From: Simon Davis
Sent: 30 November 2020 17:43
To: Planning Scanning
Subject: FW: AW/319/20/DOC - The Former Ship Inn Aldwick Street (Condition 2)

Application Correspondence "Applicant Response to Drainage Engineer Comments"

Subject: AW/319/20/DOC - The Former Ship Inn Aldwick Street (Condition 2)

Block Plan
scale 1:500 @ A1

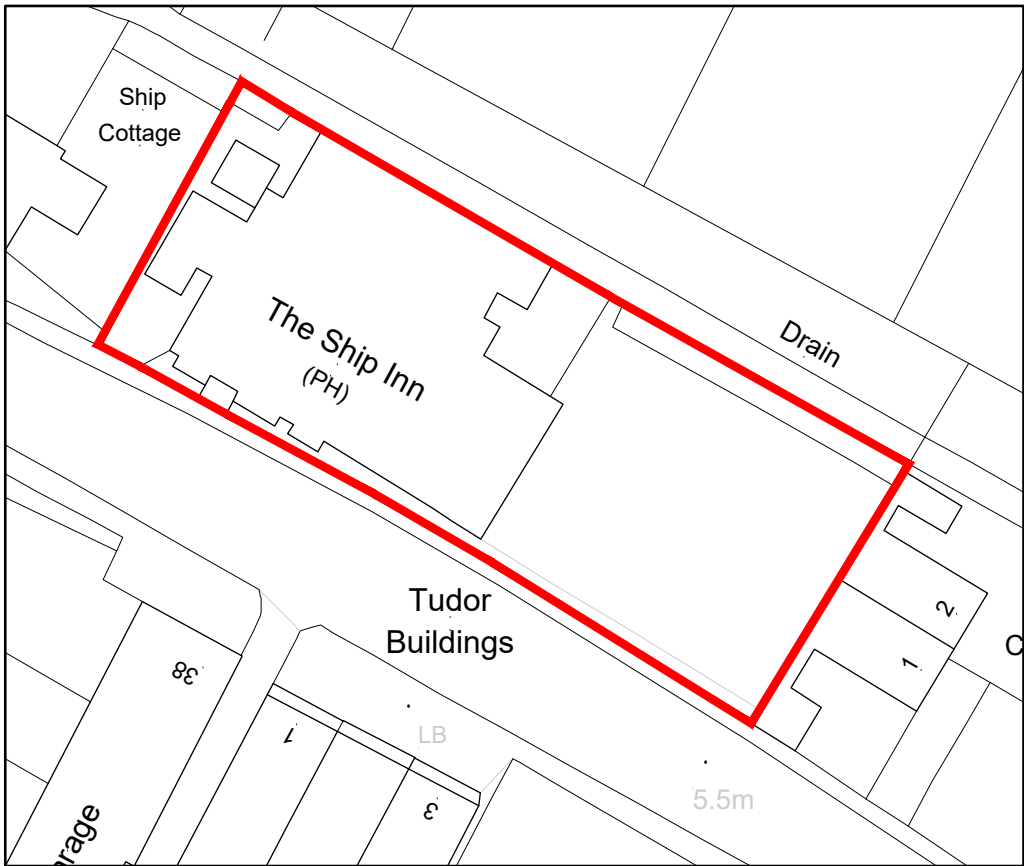
"Please can a plan showing the location of the proposed fence relative to top of bank of watercourse be supplied, what distance is being provided between the top of bank and the fence line? A 900mm access gate is suitable for pedestrian access. However, maintenance will likely require mechanical plant access. We therefore request that in addition a demountable fence is specified to permit access of mechanical plant as and when required. We would like to take this opportunity to remind the applicant that maintenance should be an annual activity. Vegetation, and litter should be managed each year and desilting undertaken as required."

Regarding the provision of a plan, I am not convinced that this is necessary in this instance. A bank is referred to in the below response, however, there is no bank to this watercourse. The rear boundary wall, which is also the rear wall of the building, is the edge of the watercourse. This wall extends as a retaining structure along the watercourse, to provide the raised ground to the car parking area. Also, in terms of the position of the fence, this will be at the location of the existing, badly dilapidated one, set inside the boundary areas and on my clients land, as otherwise indicted/shown with the submission drawing already in your possession.

With regard to the request for a demountable fence being provided, you will note from the already submitted details, that the fence is of a bolted site assembly type. It can therefore be easily dismantled. To further aid accessibility, we shall provide the post nearest the gate leading edge/lock, to have a bolted cleat fixing, rather than being cast into concrete. With the post and single adjacent panel removed, and the gate in an open position, then access will be available for all of the below activities to the watercourse.
